Highway Design Comments			
Comments provided by:	Shahzad Mirza		
Date:	Tuesday, 29 December 2020		
Planning Application No.	2020/94203	Planning Officer	Adam Walker
		Highway Officer	Mark Berry
		Applicant:	Rosie Carr
Planning Application Details:	<ul style="list-style-type: none"> <li>Proposed Residential Development On Land Off Leeds Road, Howden Clough, Birstall WF17 0HW</li> </ul>		
Reviewed Drawing Nos.	<ul style="list-style-type: none"> <li>RCLR-MWA-XX-XX-DR-A-0001-P01_ Location Plan</li> <li>RCLR-MWA-XX-XX-DR-A-0002-P01_ Topographical Survey</li> <li>RCLR-MWA-XX-XX-DR-A-0003-P02_ Proposed Site Layout</li> <li>RCLR-MWA-XX-XX-DR-A-0004-P01_ Proposed Site Layout-Presentation</li> <li>RCLR-MWA-XX-XX-DR-A-0006-P01_ Indicative Long Section and Street Scene</li> <li>E20/6960/01A_ Drainage Feasibility Plan</li> </ul>

5.0 Movement

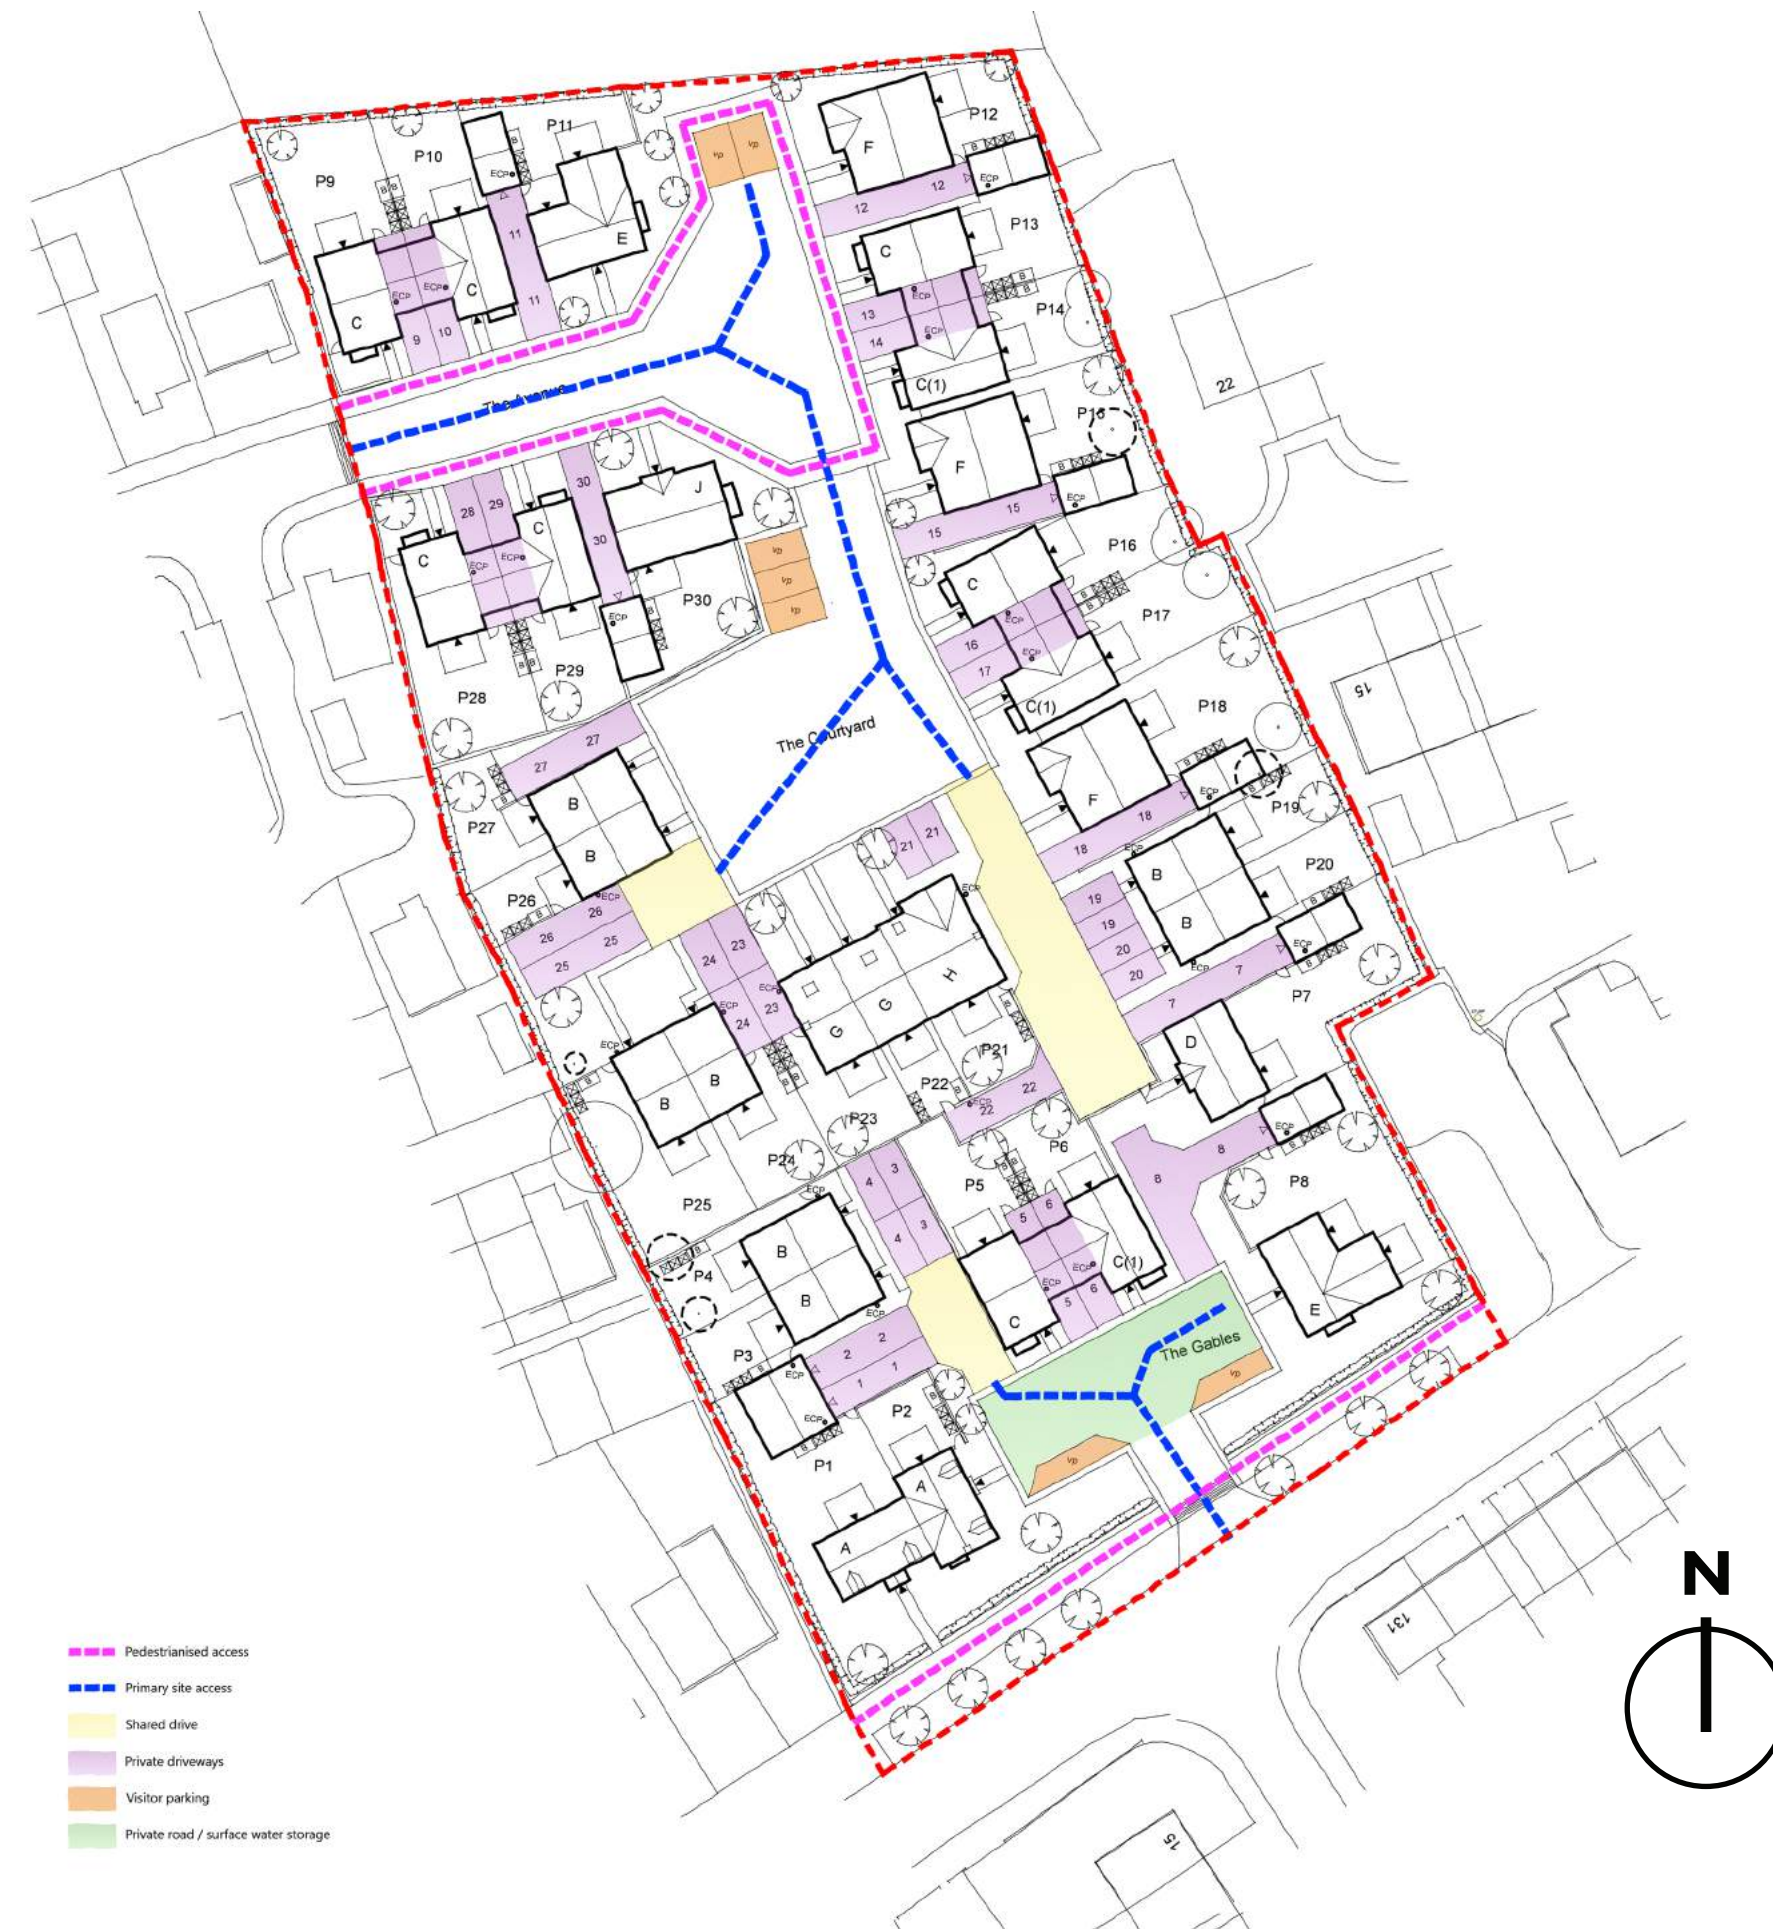
- i.** Provision of visitor bays must to a ratio of 1:4 to the total number of dwellings proposed. Therefore, provision for 8 no. bays needs to be made, where only 7 are proposed;

- ii.** All visitor parking bays need to be parallel to the proposed internal roads that should be ideally created as lay-bys and staggered across the overall development area;

- iii.** The main internal road alignment into the site seems jagged in places and has very tight centreline alignment- this is unacceptable. A minimum 20m centreline radius on the internal road should be used to ensure refuse swept paths of refuse vehicles are not compromised;

- A pinch point is proposed near plot no.18. This needs to be eliminated. 5.5m carriageway with 0.6m hard margin on either side should allowed for;
  - Visitor bays are proposed near plot no. 11 & 12. These should be relocated as they compromise the necessary turning head area;

Proposed Long Section

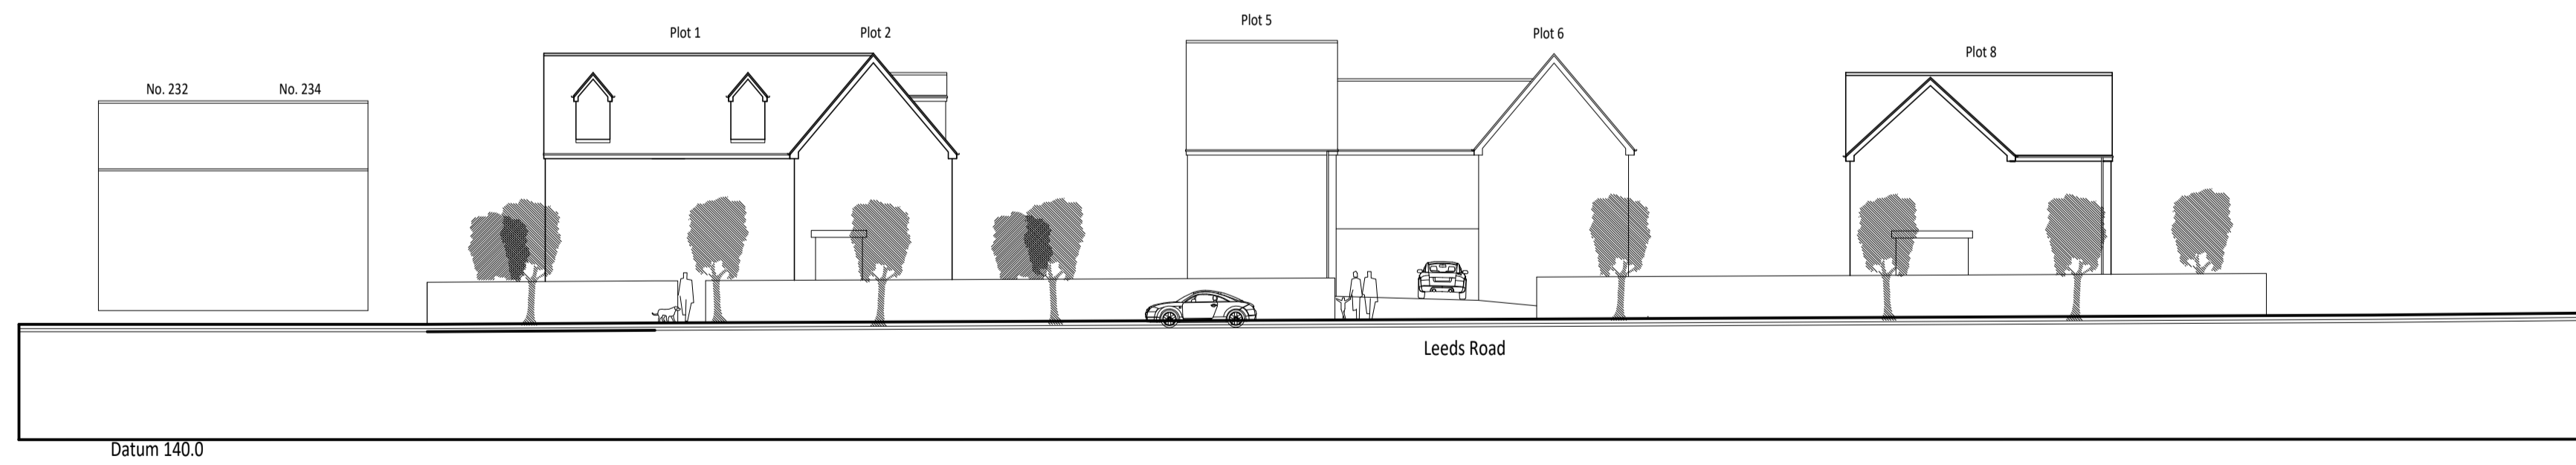
- xix.** The site fall from Moat Hill Farm Drive to Leeds Road at a slope of circa 1:12. Given this the proposed roads need to comply with the following:-

- Given the significant level differences to road with intermittent 1:10 longitudinal gradients can be considered for adoption. A road with 1:10 gradient throughout would not be acceptable as it prejudice against disable users.

- i.** For a full application site contours, plot finished floor levels and proposed road contours/road long sections are necessary for our full assessment. Complete information was not made available on this occasion;
